INDIVIDUAL PLANNING OBJECTION

Waterloo South SSDA — SSD-93222706

6/123 Cooper Street, Waterloo NSW 2017 — PT 34 — SP79210

Drawing Name
Blocks 2 & 3
 Proposed Envelope -
 Sections 01 & 02

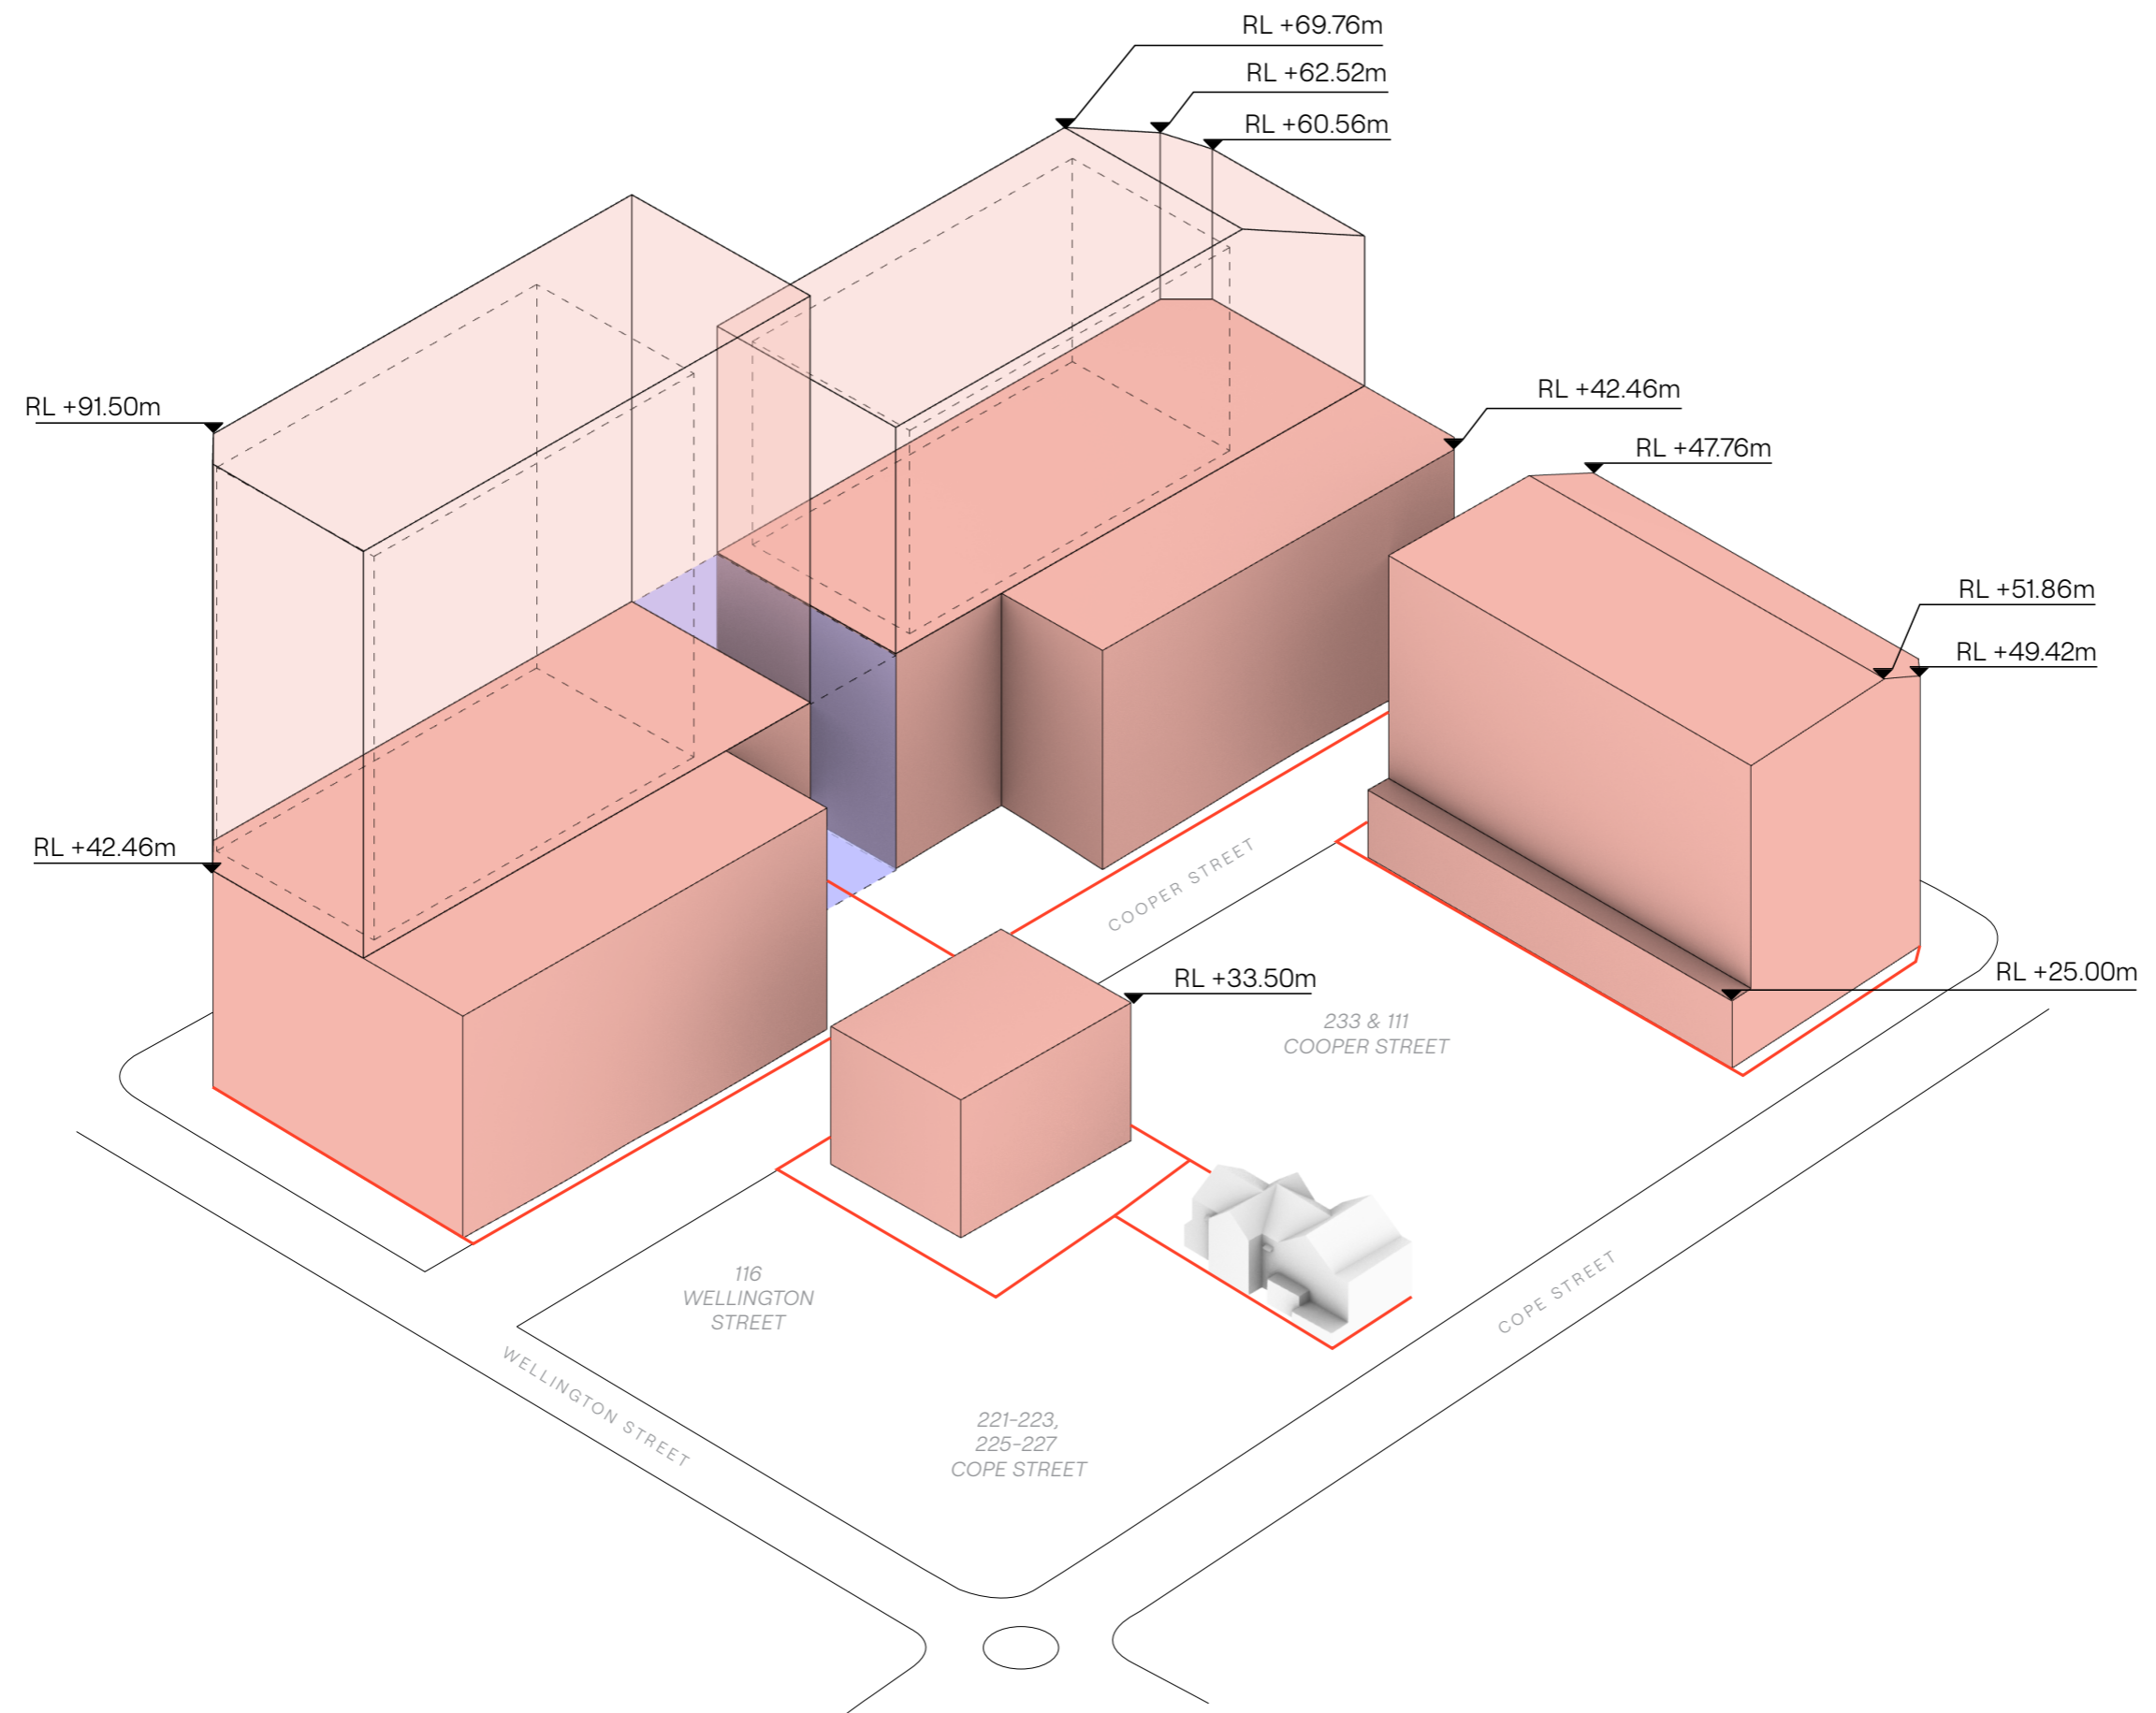
- **Loss of solar access and daylight to my private courtyard:** My apartment receives its primary natural daylight through my private open-air courtyard. The proposed development will enclose 123 Cooper Street on both sides of Cooper Street: Lot 2D (9 storeys, RL +51.86m) to the south-west and Lots 3A (22 storeys, RL +91.50m) and 3B (15 storeys, RL +69.76m) directly opposite on the eastern side. Together these envelopes will substantially reduce the angle of sky visible from my courtyard and eliminate direct solar penetration. No solar access analysis has been conducted for any privately owned property at 123 Cooper Street under SEAR 7.

- **Privacy and overlooking:** The proposed tower envelopes will provide direct overlooking from elevated floors into my private courtyard space — an open-air habitable area I currently use without any awareness of being observed from above. No privacy or overlooking assessment has been conducted for the private courtyards of 123 Cooper Street.

- **Carpark traffic on narrow footpath:** The Block 2 carpark entry on Cooper Street will introduce vehicle movements directly onto the narrow footpath through which I access my home at 123 Cooper Street. The footpath depth between the building boundary and the roadway is limited. This pedestrian safety impact has not been assessed.

- Require supplementary solar access and daylight analysis specifically modelling overshadowing impacts on the internal apartment courtyards of 123 Cooper Street, with explicit consideration of mould and building health risks, as a condition of approval
- Require a specific privacy and overlooking assessment for the open-air private courtyard spaces of 123 Cooper Street
- Require ADG separation compliance to be demonstrated for Lot 3B (1.5m setback, 15 storeys) opposite the habitable rooms of 123 Cooper Street
- Require a Construction Environmental Management Plan addressing dust, noise and vibration impacts on privately owned properties on Cooper Street prior to any demolition or excavation
- Appoint the Independent Planning Commission as consent authority, given the number of objections and the contentious nature of this application
